LOCAL IMPACT REPORT

BROADLAND DISTRICT COUNCIL

APPLICATION BY: Orsted Hornsea Project Three (UK) Ltd. for an Order Granting Development Consent for the Hornsea Project Three Offshore Wind Farm Project.

PLANNING INSPECTORATE REF: EN010080

Figure 3.21 Construction Compound Options.

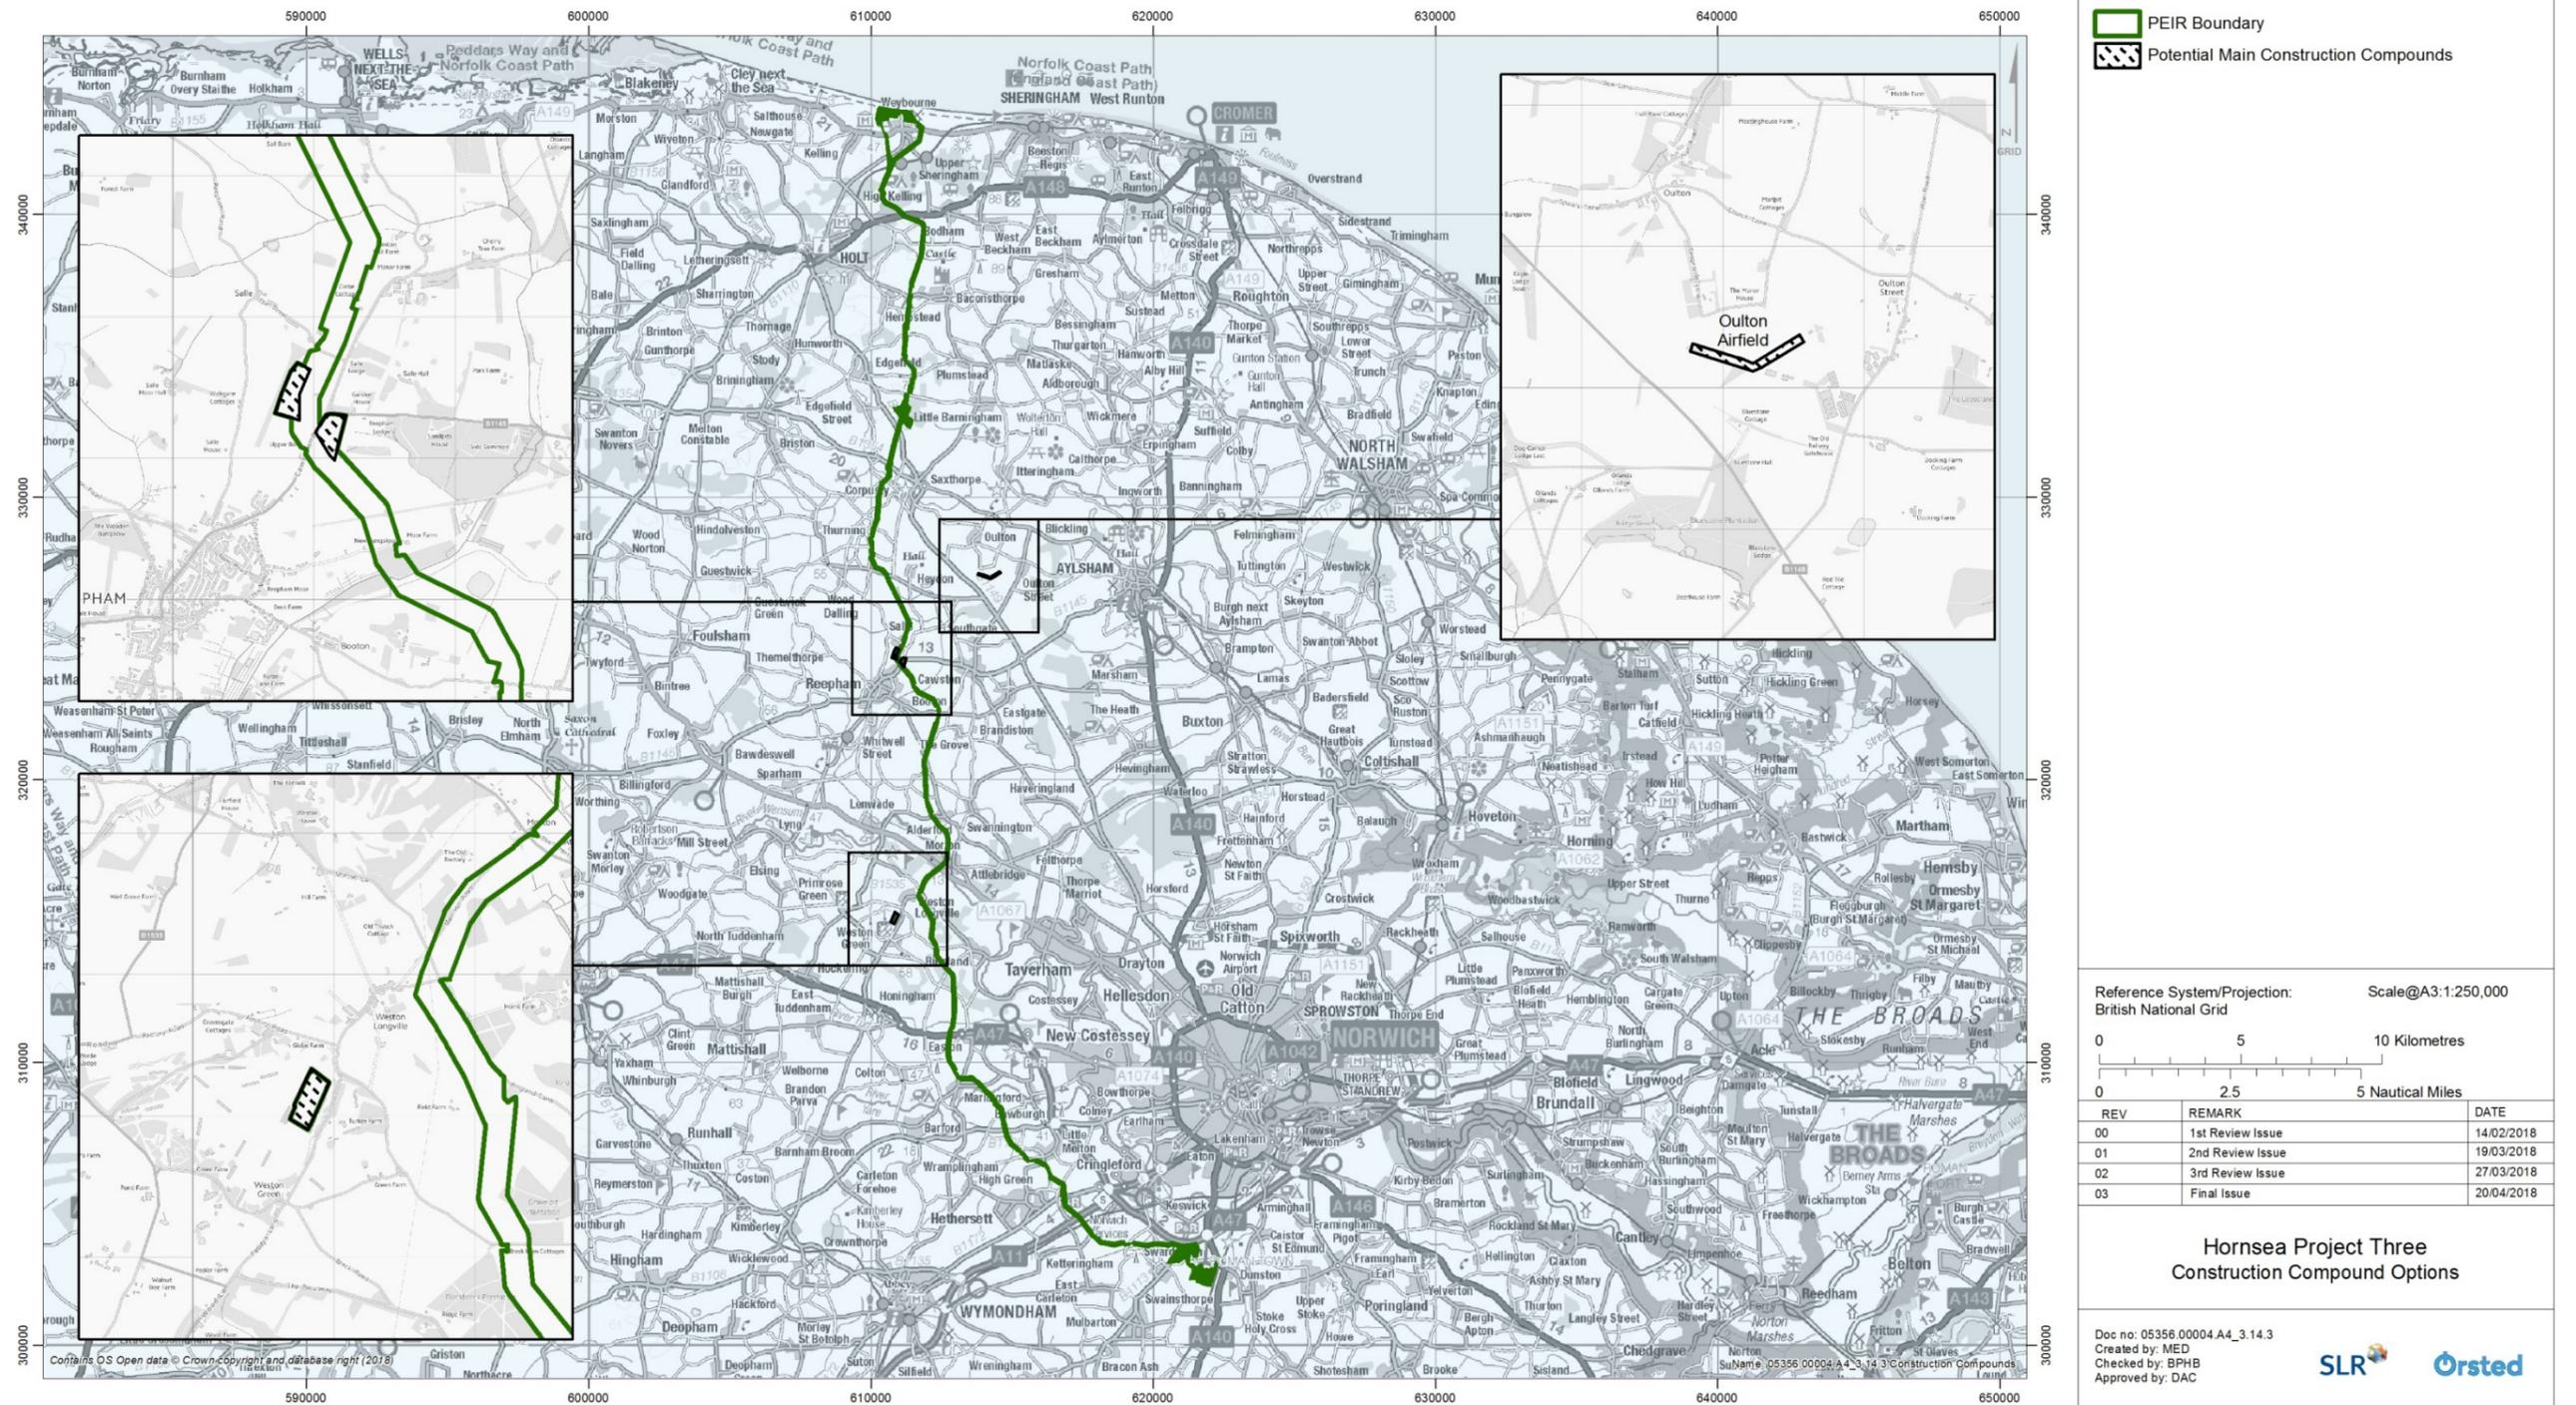
- 5.4 The main construction compound for the entire on-shore construction phase is proposed to be located on part of the former Oulton airfield within the parish of Oulton. The former airfield is southwest of the small village of Oulton, part of the village and the surrounding area has been designated as a Conservation Area within the Blickling Conservation Area, with listed buildings in the vicinity. Oulton and the surrounding area are served by narrow country lanes. The applicant states that the construction period for the onshore works would be 8 years and could be built in two development phases.

- 5.5 BDC has identified in its written response to the Examining Authority's question **Q1.15.16** that a previous planning application for an anaerobic digester (AD) plant on part of the Oulton airfield was refused under District Ref: 20130860, as referred to above at paragraph 3.4. The proposed route for vehicles associated with the AD plant was along The Street and then onto the B1149, this is the same route as the applicant's originally proposed to serve the on-shore construction compound. An appeal was submitted against the refusal and dismissed (PINS ref: APP/K2610/A/14/2212257) on grounds that the proposed development would have an unacceptable impact on highway safety and convenience and be likely to result in material harm to the living conditions of residential occupiers of The Old Railway Gatehouse with reference to noise and disturbance.

- 5.7 However the route and proposed arrangement of the vehicular access to and from the main construction compound to the B1149 and through Oulton village centre and the surrounding area for both heavy goods construction traffic and staff vehicles is still to be agreed and the applicant has produced a document

dated September 2018 'Main Construction Compound Access Strategy' which proposes four alternative options which seek to achieve an acceptable vehicular access to and from the compound. To date there has been no agreement on which option will be pursued or the detailed access arrangements/highway works that are required to be proposed and precisely what the implications of these additional proposals would be. BDC welcome continued involvement and consultation with the applicant, the Highway Authority and Oulton Parish Council as the access strategy progresses and consideration needs to be given to any impacts on highway safety, hedgerows, trees, heritage assets and the residential amenities of the occupiers including The Old Railway Gatehouse which is a residential property that is located immediately adjacent to The Street at a point of a noticeable 'hump' in the road, which is the position of the former railway.

Figure 1 – Hornsea Three, NV and NB (PEI) Project Boundaries

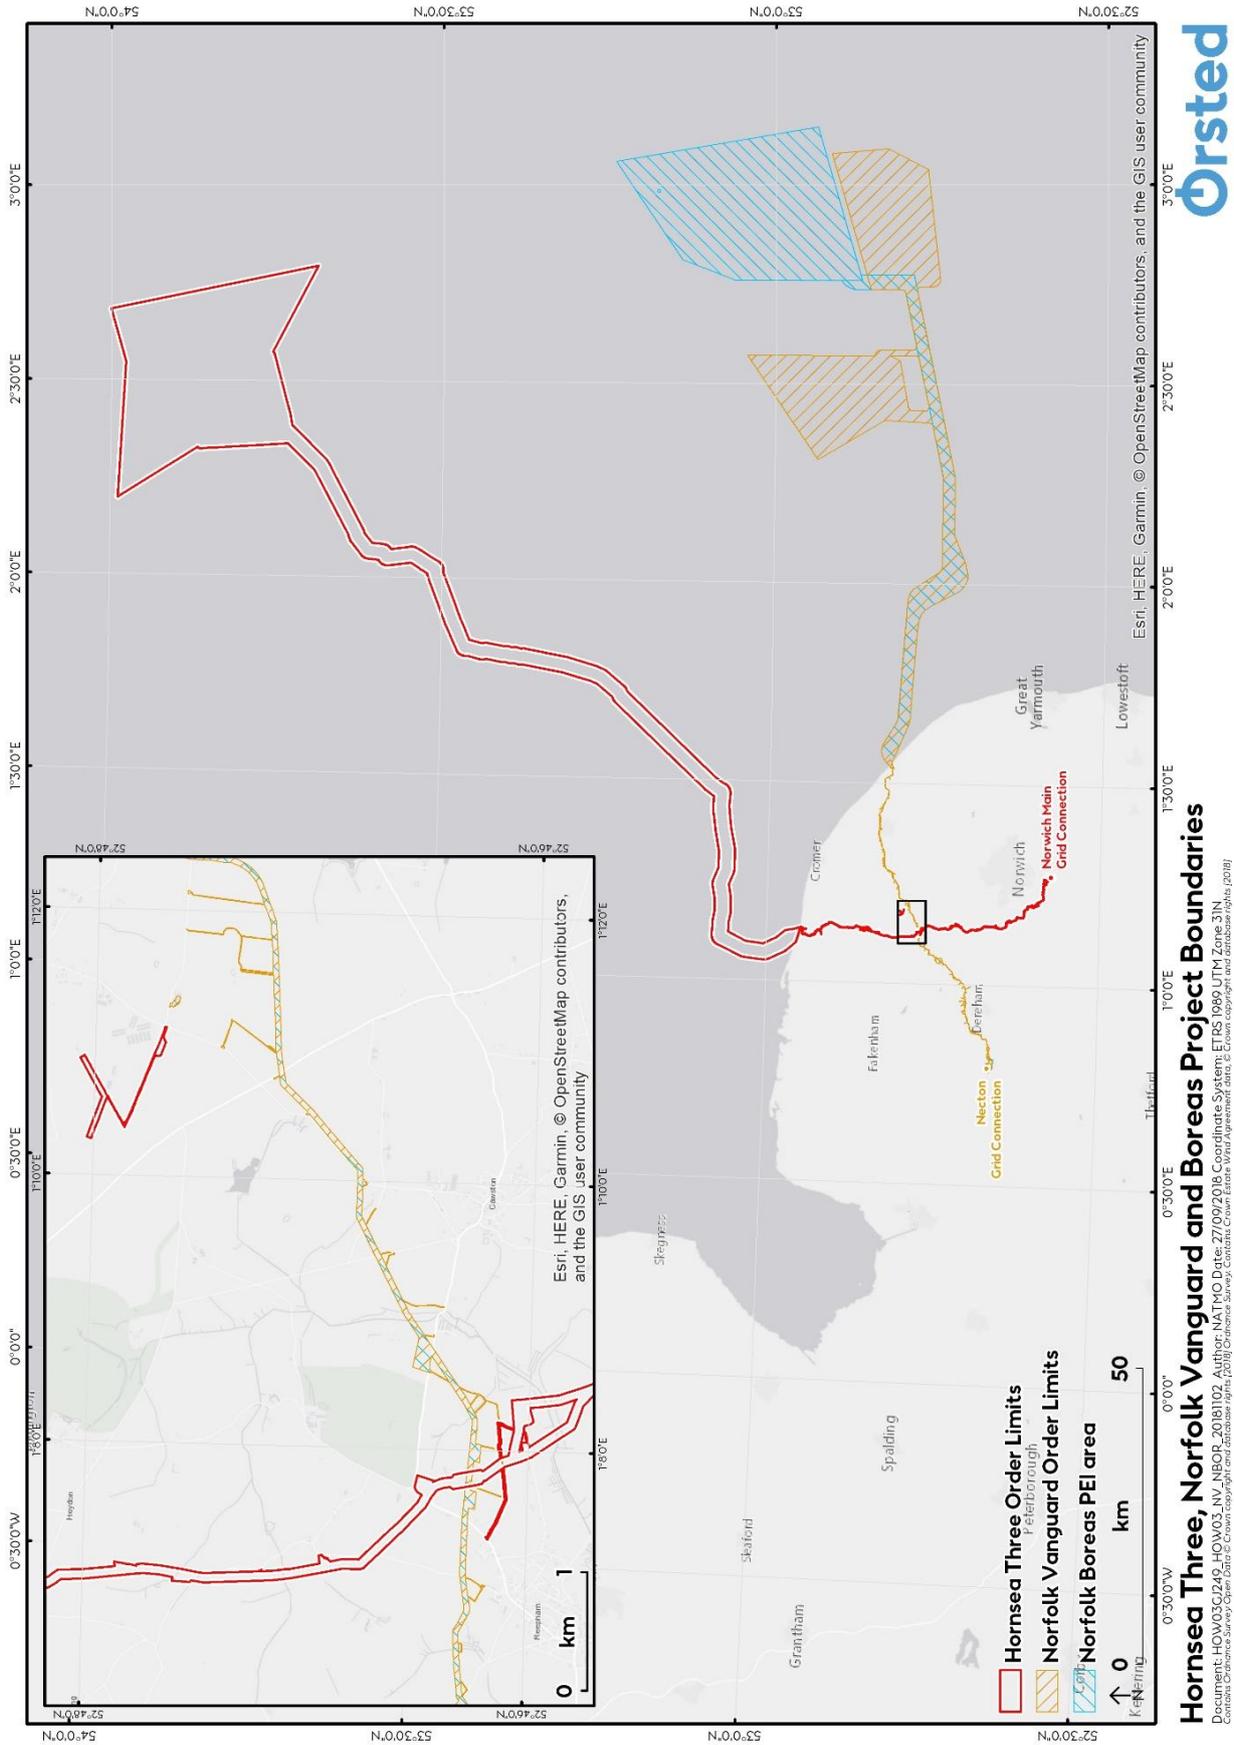
- 5.8 BDC notes that the separate Norfolk Vanguard off-shore wind farm proposals, referred to in paragraph 3.1 above, also identify its own construction and access zones to the south of Oulton in proximity to the Hornsea Three proposals and therefore the cumulative impact of both of these proposals should also be considered at this stage.
